Planning Application 2021/1089

Pollution Control Consultation – Conditions

Conditions related to Full Application:

Figure E4: 1.2m High Barrier

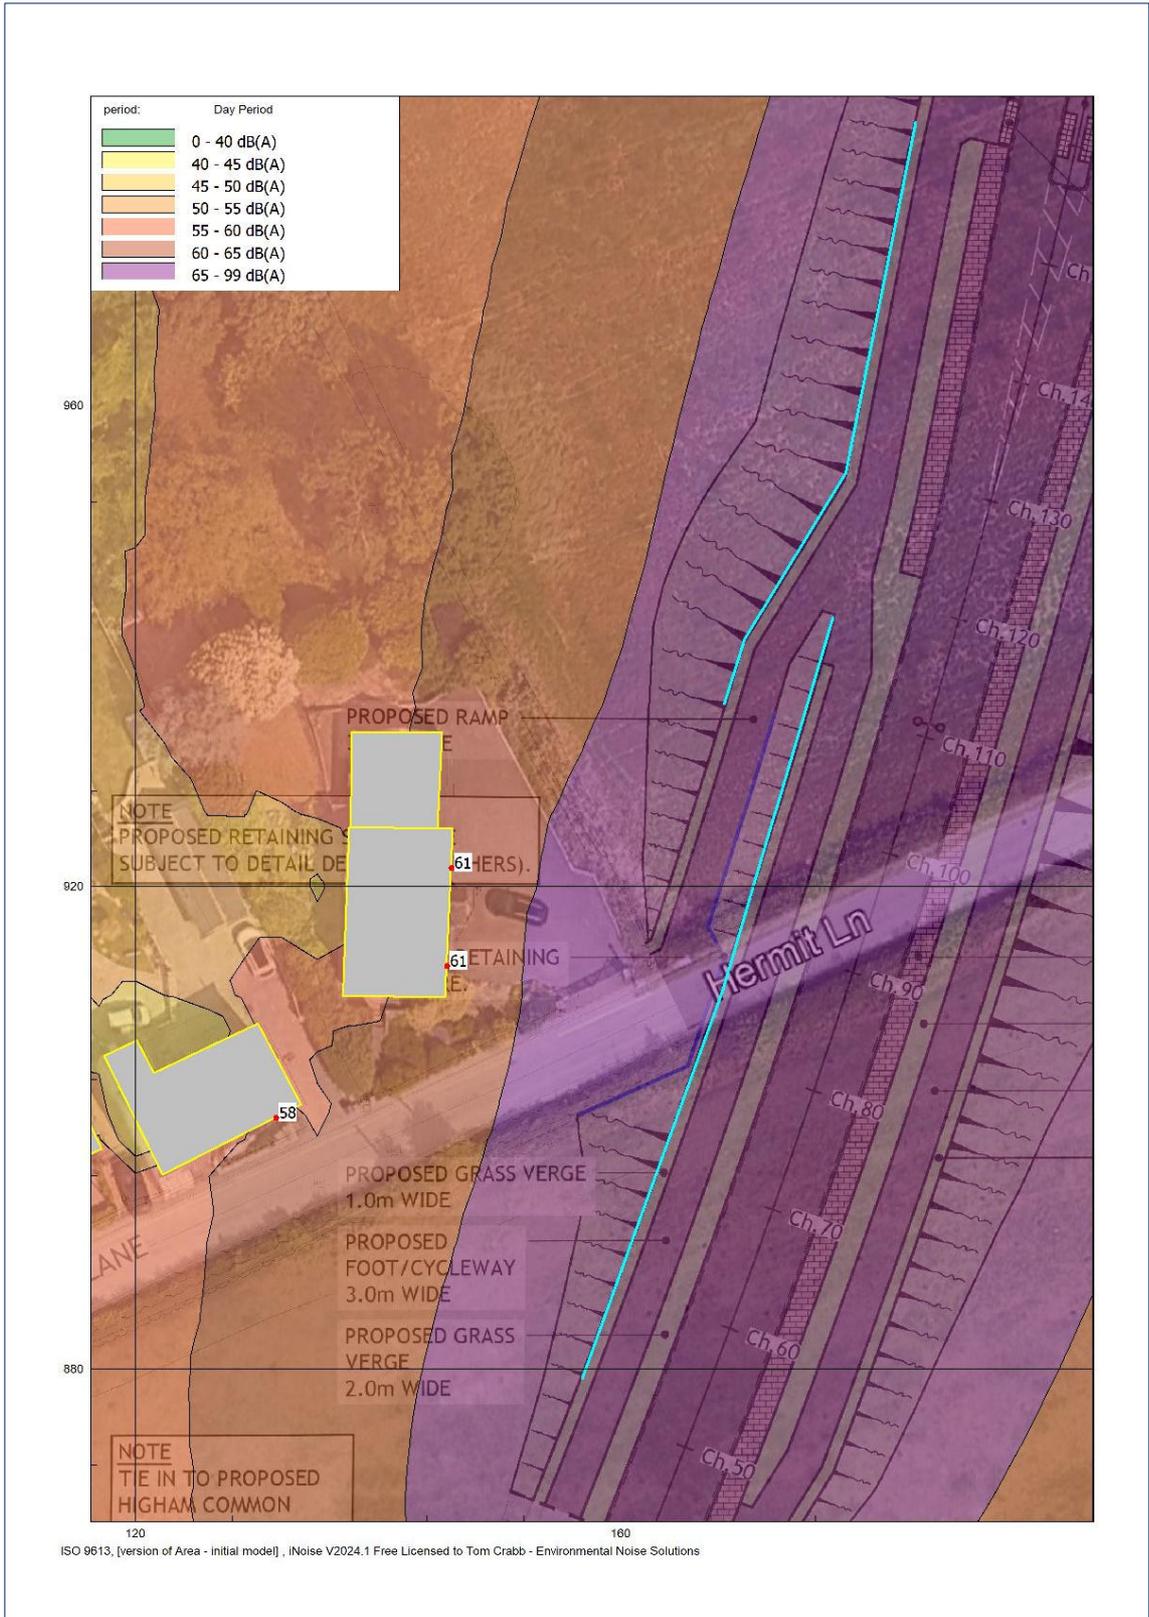
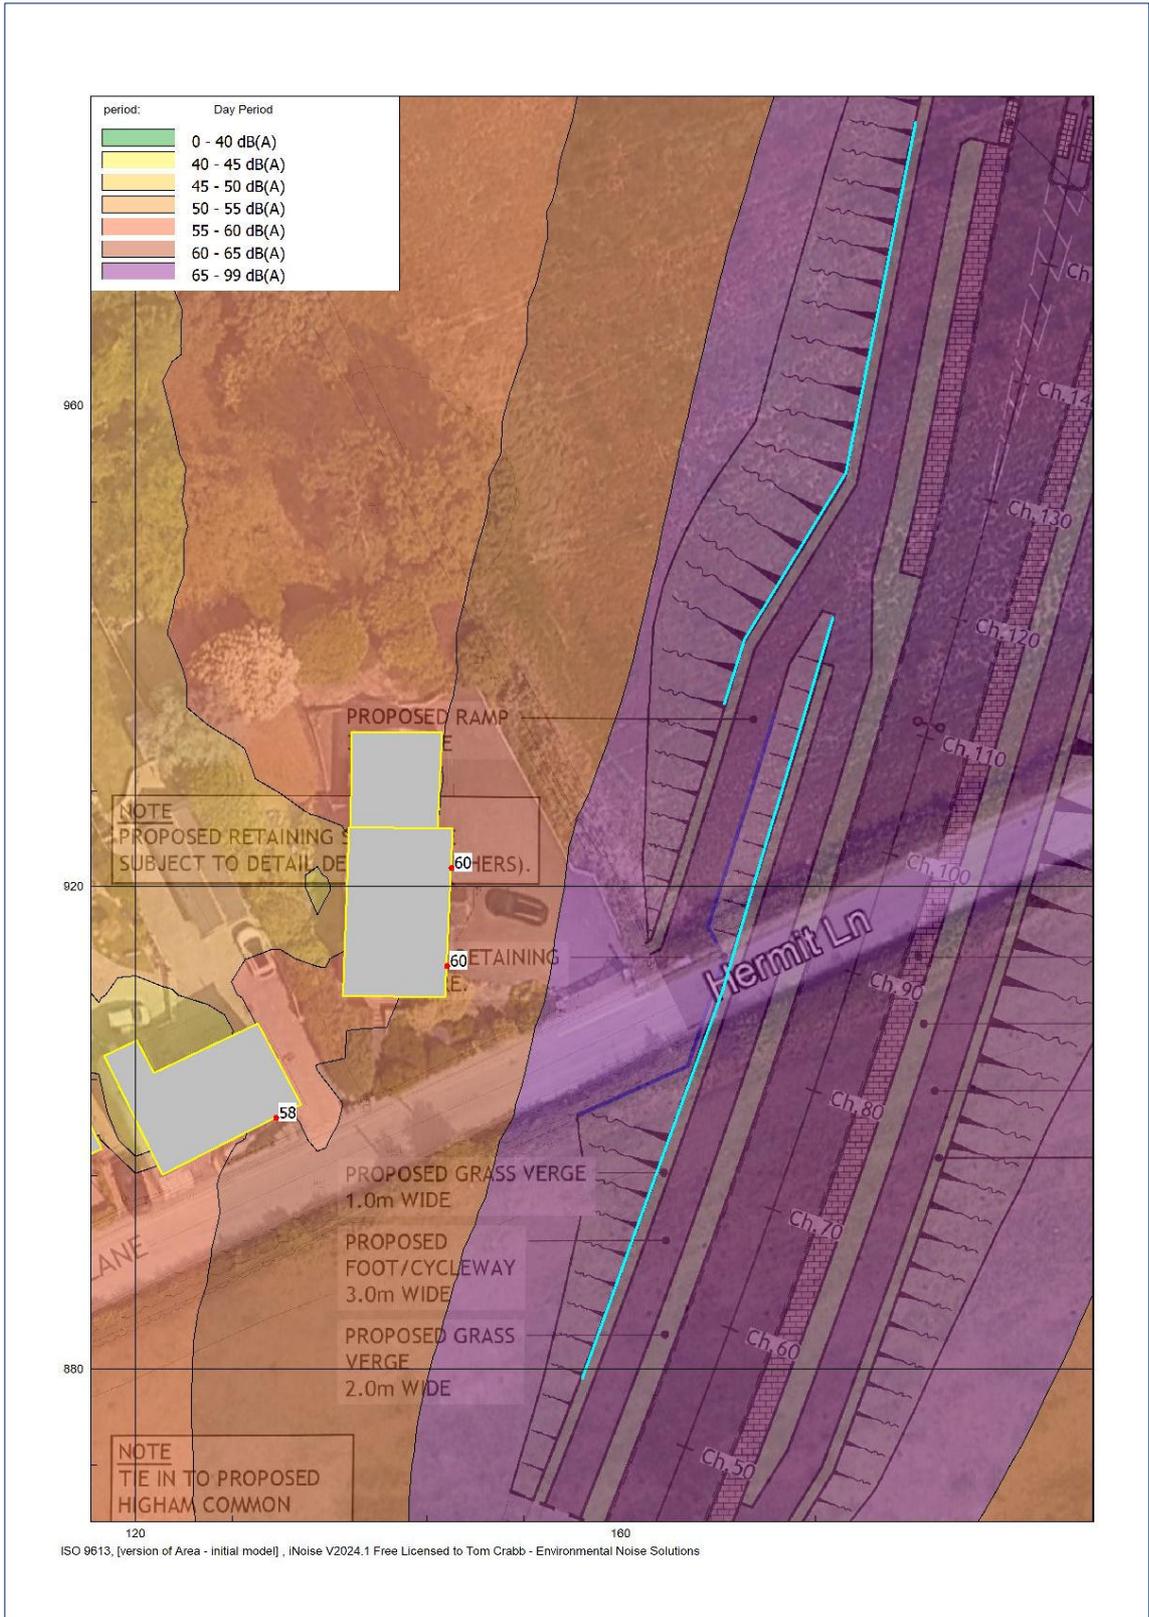
5. Prior to operation of the link road the noise barrier mitigation measures described in the report "Proposed Residential Development Barnsley West (Phase One) Land to the South of Barugh Green Road, Barnsley" produced by Environmental Noise Solutions Limited, dated 25th April 2024, ref: NIA/8576/21/9800/v3/Barnsley West (Phase 1) shall be implemented. The barrier shall be constructed at the location shown in Figure 4.1 of the report.

Note the above is based on a masonry barrier of 1.2m height. The noise consultant has confirmed that a higher barrier of 2m would provide an additional attenuation of 1dB.

**Appendix 13.1 – Figure 4
Construction Phase Work Areas (Assumed)**

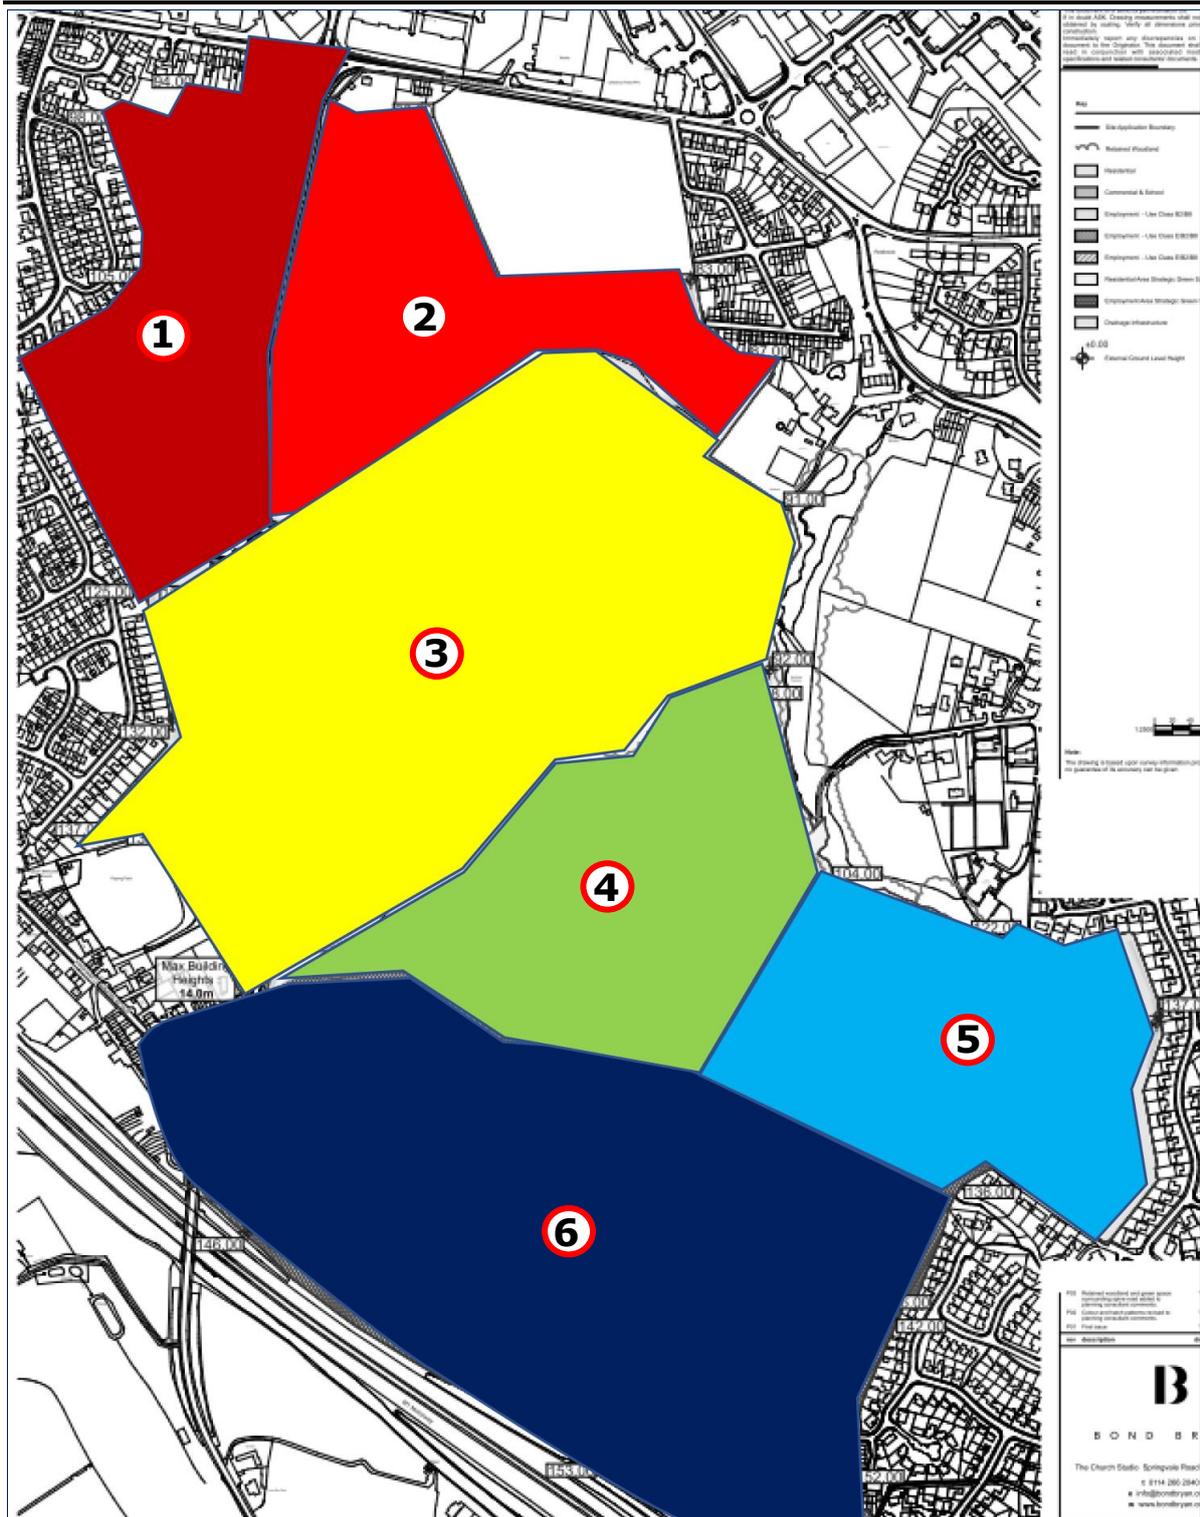
- Measures to control the emission of noise from consolidation works
3. Prior to commencement of any residential construction, earthworks, groundworks, demolition or remedial works in Area 1 (as identified in Appendix 13.1 Figure 4 of document [‘20211090 015 ES Chapter 13 Appendix 13.1 Figures 1 – 8’](#)), the mitigation measures described in [‘20211090 015 ES Chapter 13 – Noise; section 13.5.2’](#) shall be implemented. The scheme shall be maintained and not altered without the prior permission of the Local Planning Authority.

Commented [CM,E(HO1): Needs updating to 2023 submission
